Listed building consent to form new external door opening to west elevation.

The Royal Norfolk Hotel The Esplanade Bognor Regis

ROYAL NORFOLK HOTEL – EXISTING STAFF ROOMS ON GROUND FLOOR SCALE 1:50 AT A4

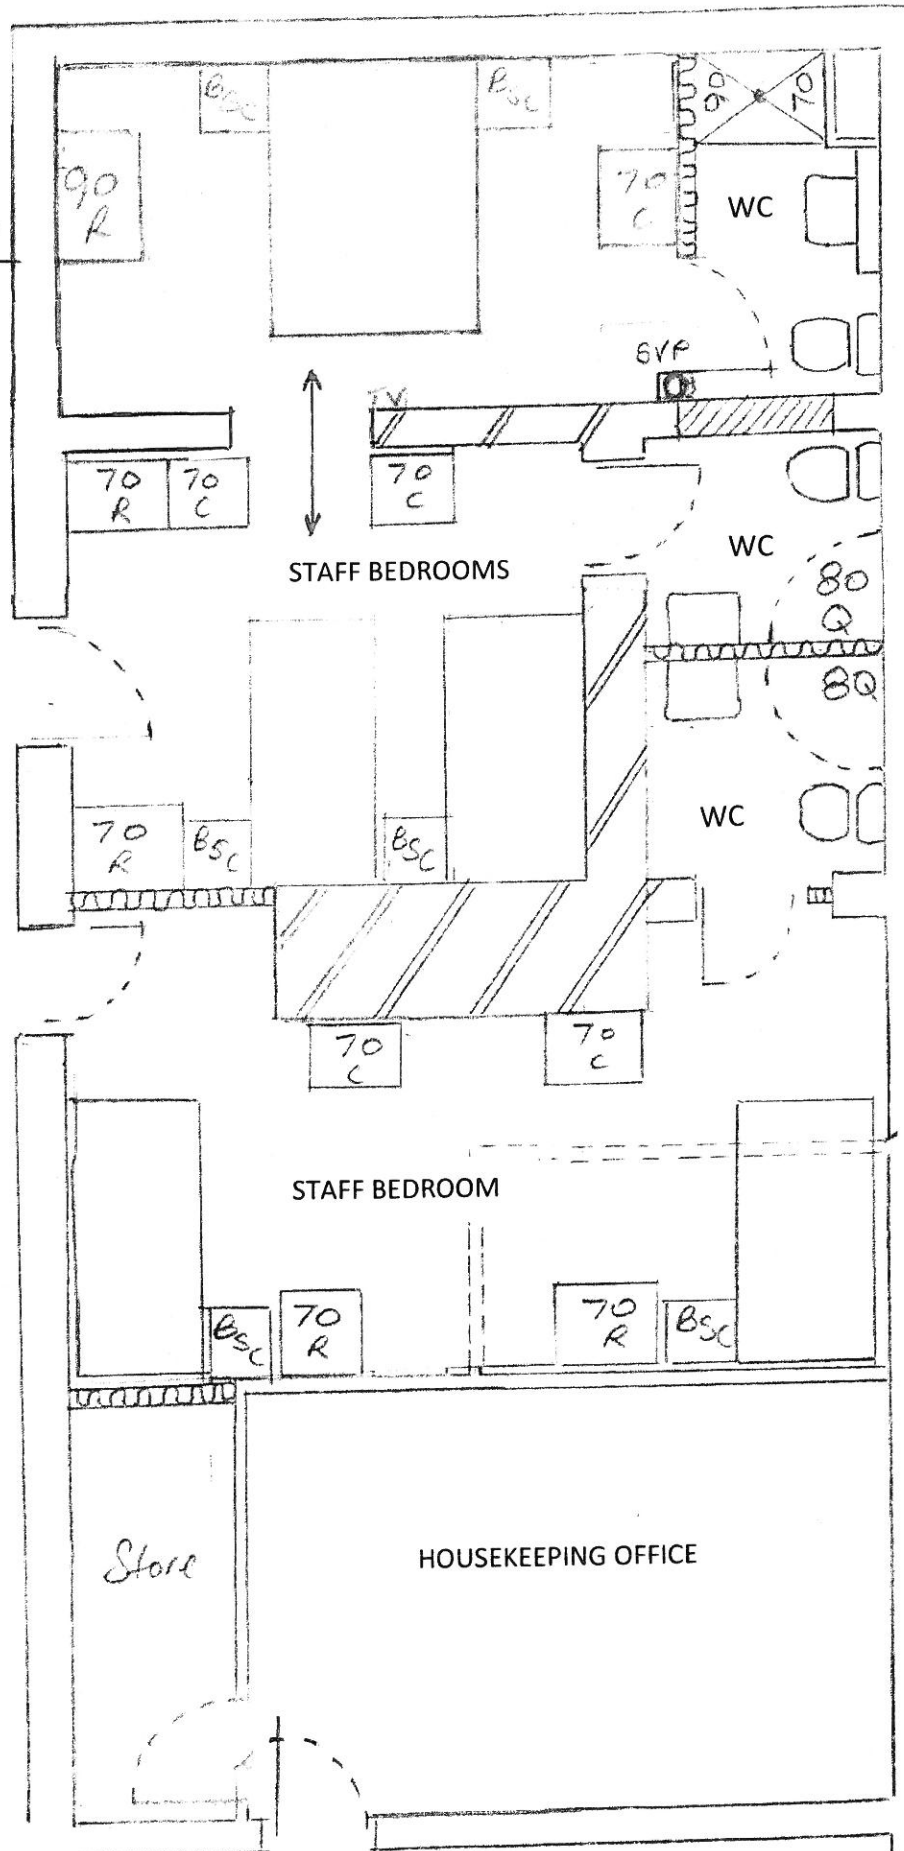
The new door should match the existing two doors.
